Our Case Number: ABP-317660-23

Re: Busconnects Kimmage to city centre core bus corridor scheme
Kimmage, Dublin

Observation on Bus Connects Kimmage Core Bus Scheme

**Figure 4.2: Proposed scheme design and parking changes along Kimmage Road Lower**

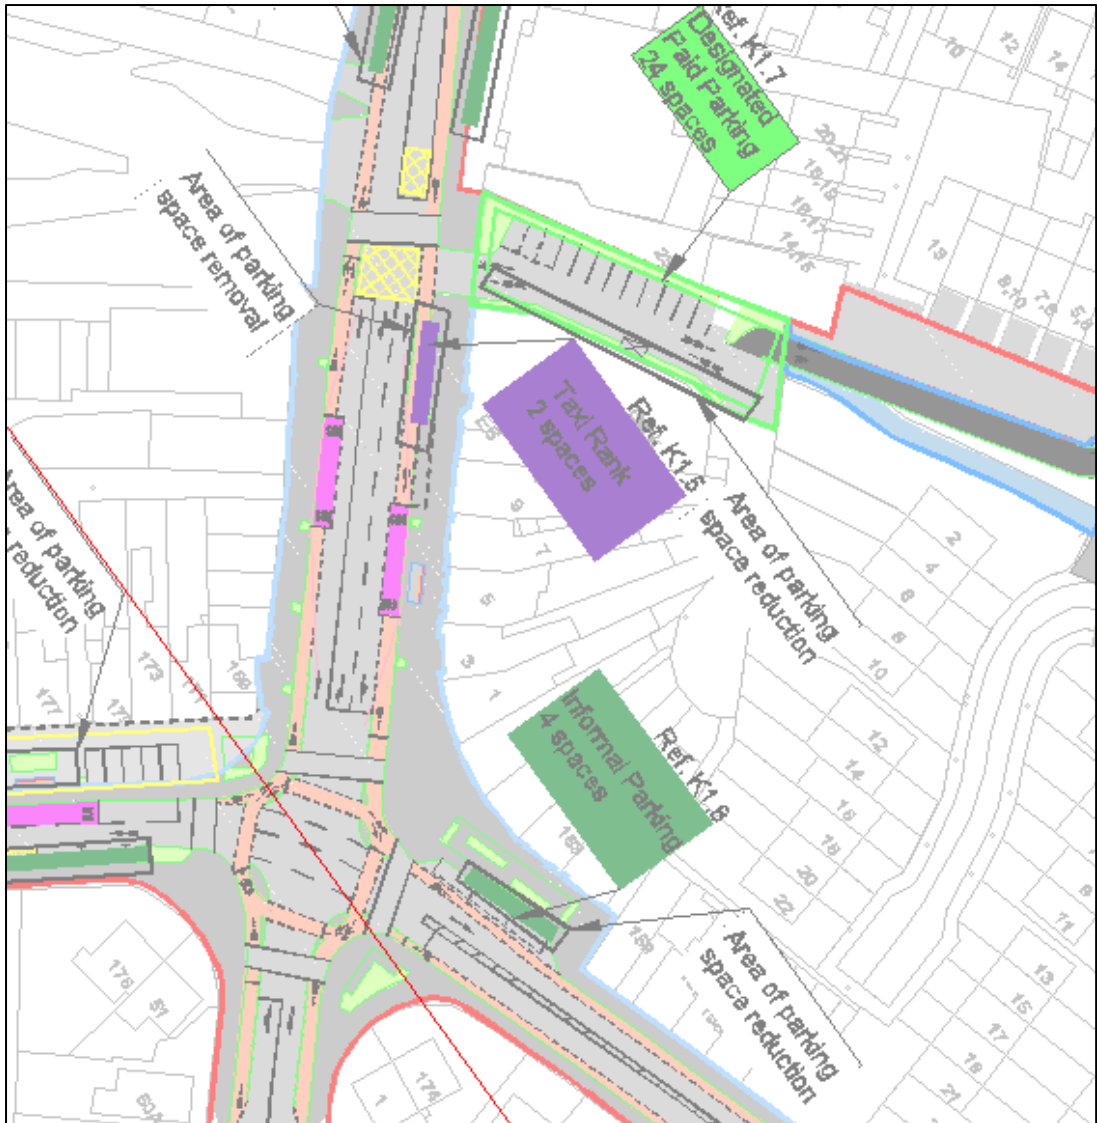
The current Bus Connects plans shows the removal of pedestrian footpath and a portion of the apron at the main gate at the south end of Harolds Cross Park as per the extract shown above.

The proposal to remove the footpath is to protect onstreet car parking spaces and to speed up car traffic speeds. This seems to me to be the complete opposite of the stated aim of the project.

6. The proposed increased width of the vehicular lane is in excess of what is required. The current width of the vehicular lane facilitates a two way traffic which works well. It reduces traffic speeds along this stretch of street and facilitates pedestrian movement across the road and entering and leaving the park. Existing parking bays also slows traffic movement along this busy pedestrian route between bus routes.

The proposal to remove the footpath should be removed in total from the scheme. It is explicitly against the stated objectives of the Bus Connects scheme. It reduces pedestrian facilities purely to speed up private car traffic. It ignores the historic trees within the park which will be destroyed by the construction of a wider road service. It ignores the historic kerbing and railings to the park. It forces pedestrians on a roundabout route to facilitate private cars. There are two primary schools and one secondary school in the immediate area - this proposal will only hinder attempts to increase walking and cycling to school.
